Proposed Addendum 06 – POST BIDDate: April 16, 2004

Regarding: **Logan Place SRO Apartment – Bidding Documents**Subject: **Proposed Addendum 06**

The following addendum items apply to the project known as the **Logan Place** located in Portland, Maine.

A BUILDING SECTION
SCALE: 1/4" = 1'-0"

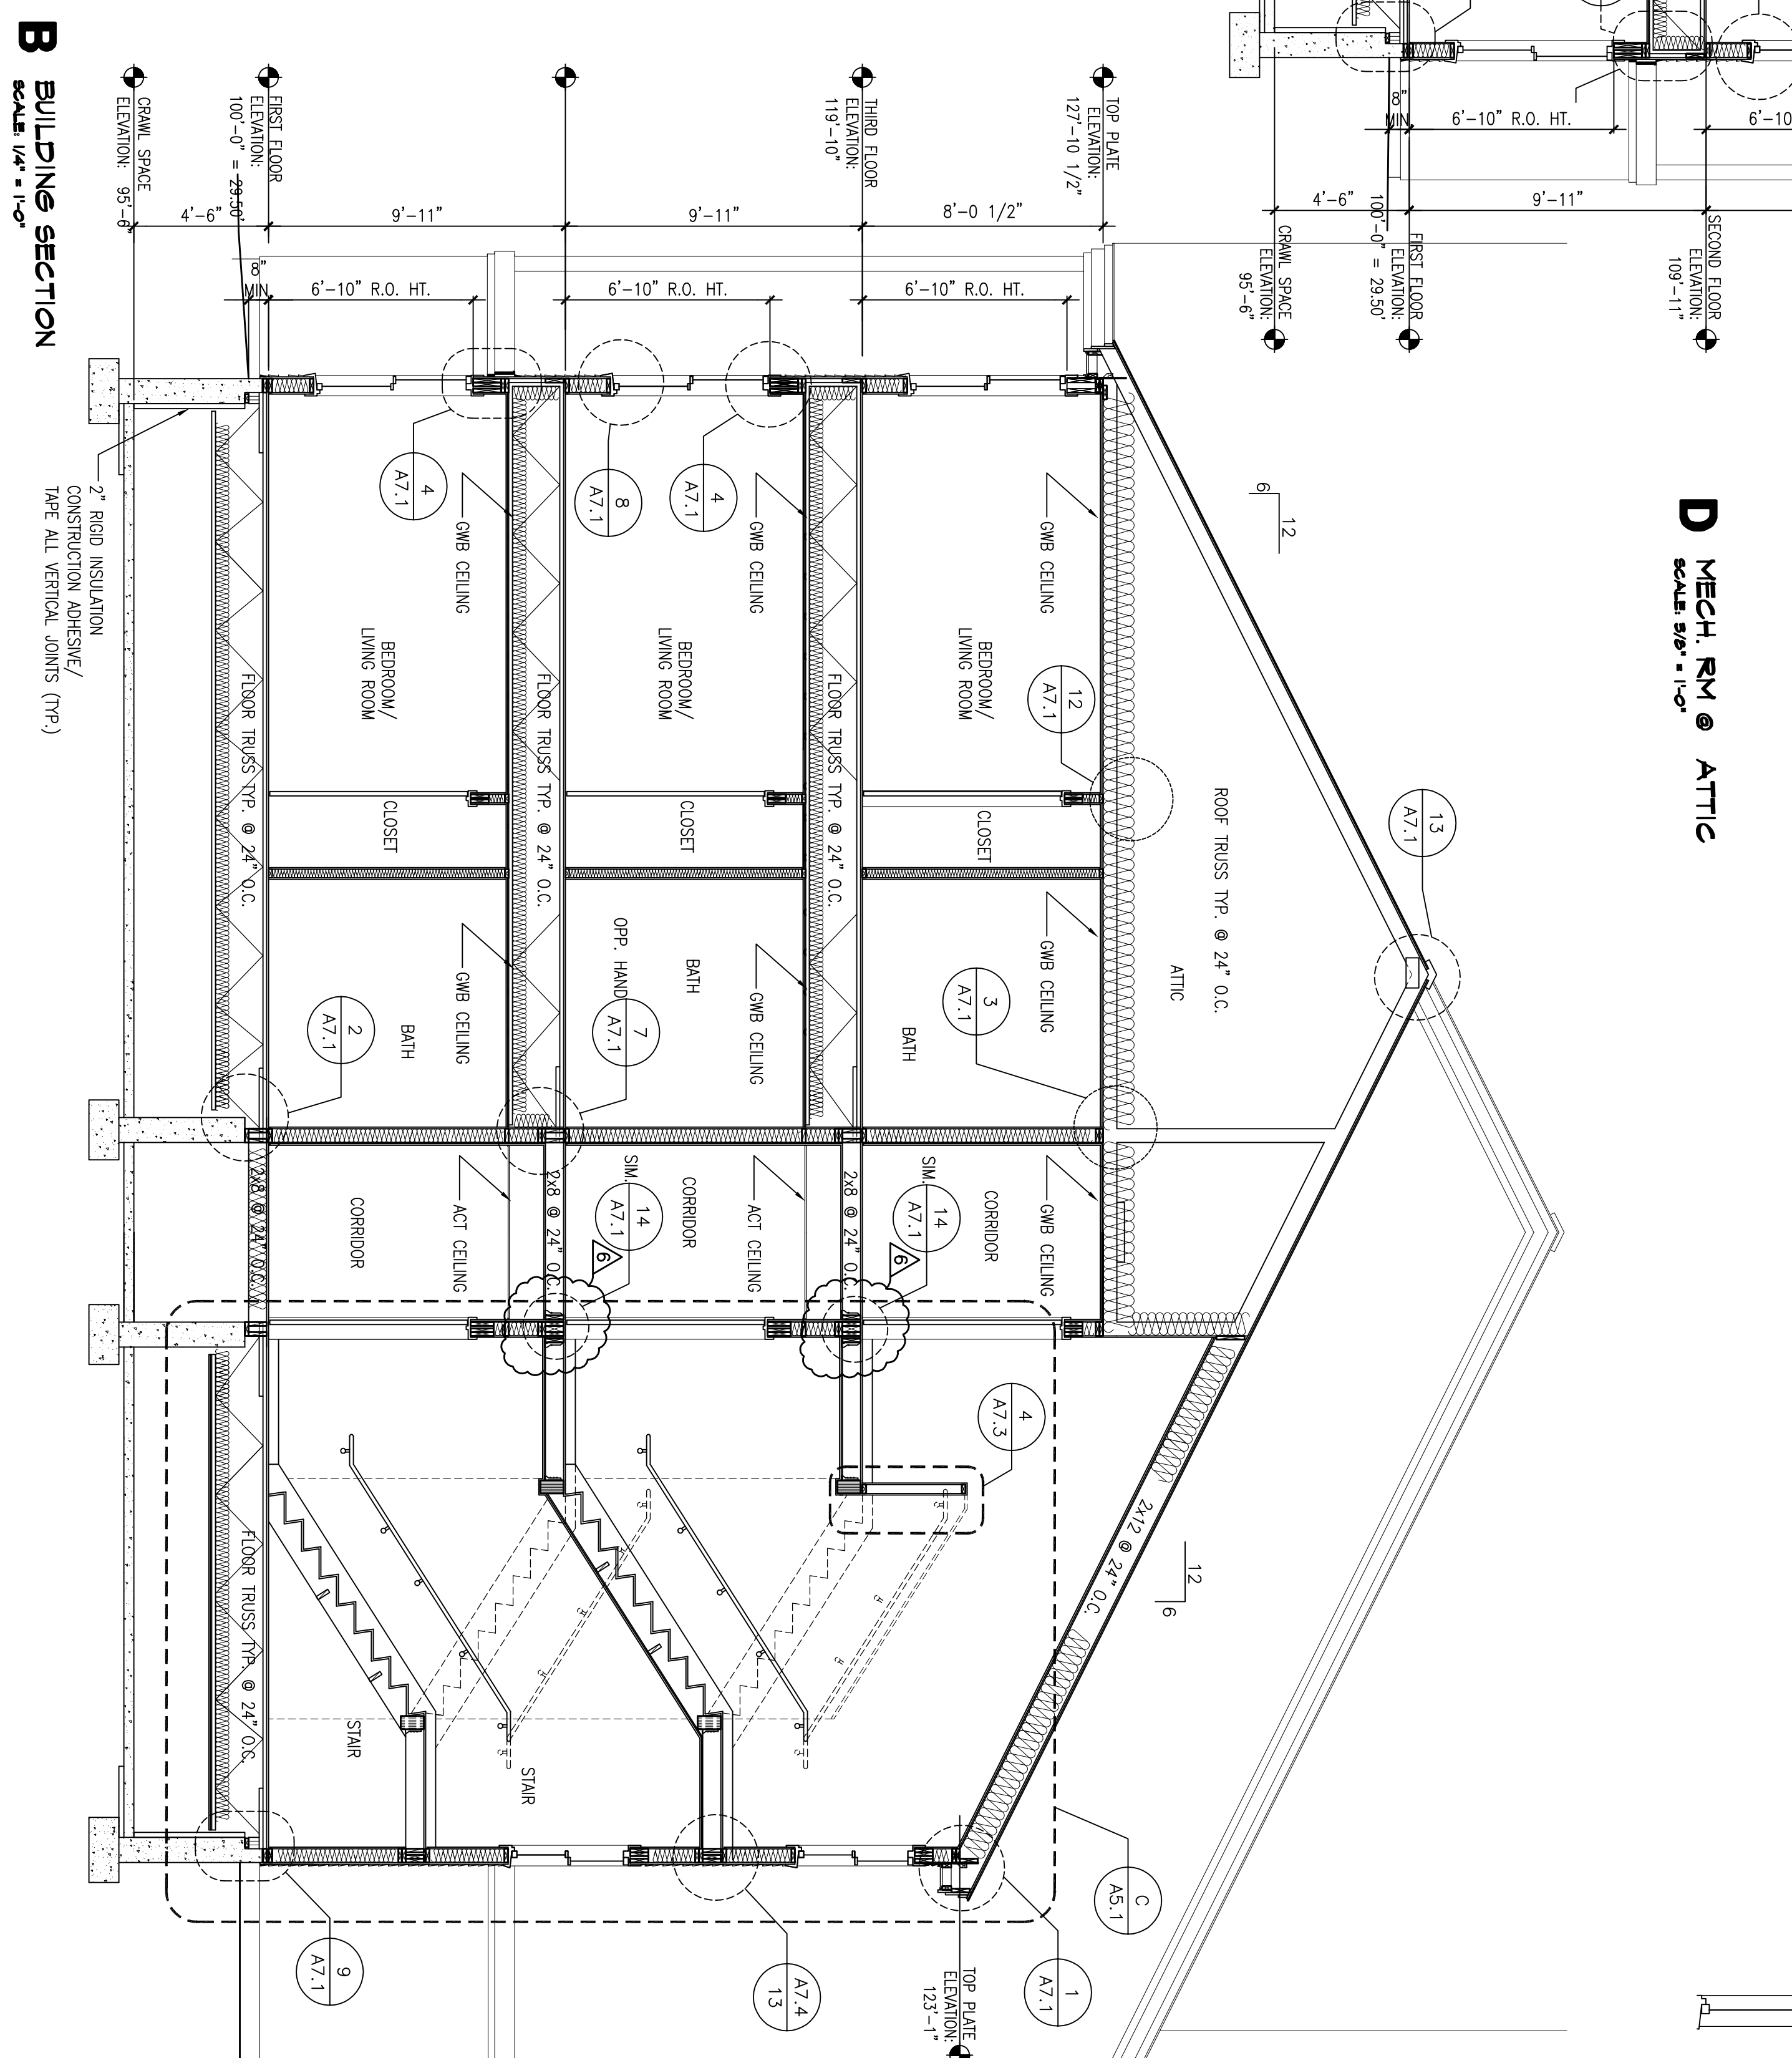
6. See revised drawing A5.1 for revised Stair Section C – indicated with revision cloud.
7. See revised drawing A7.1 for added new detail 14 – indicated with revision cloud.
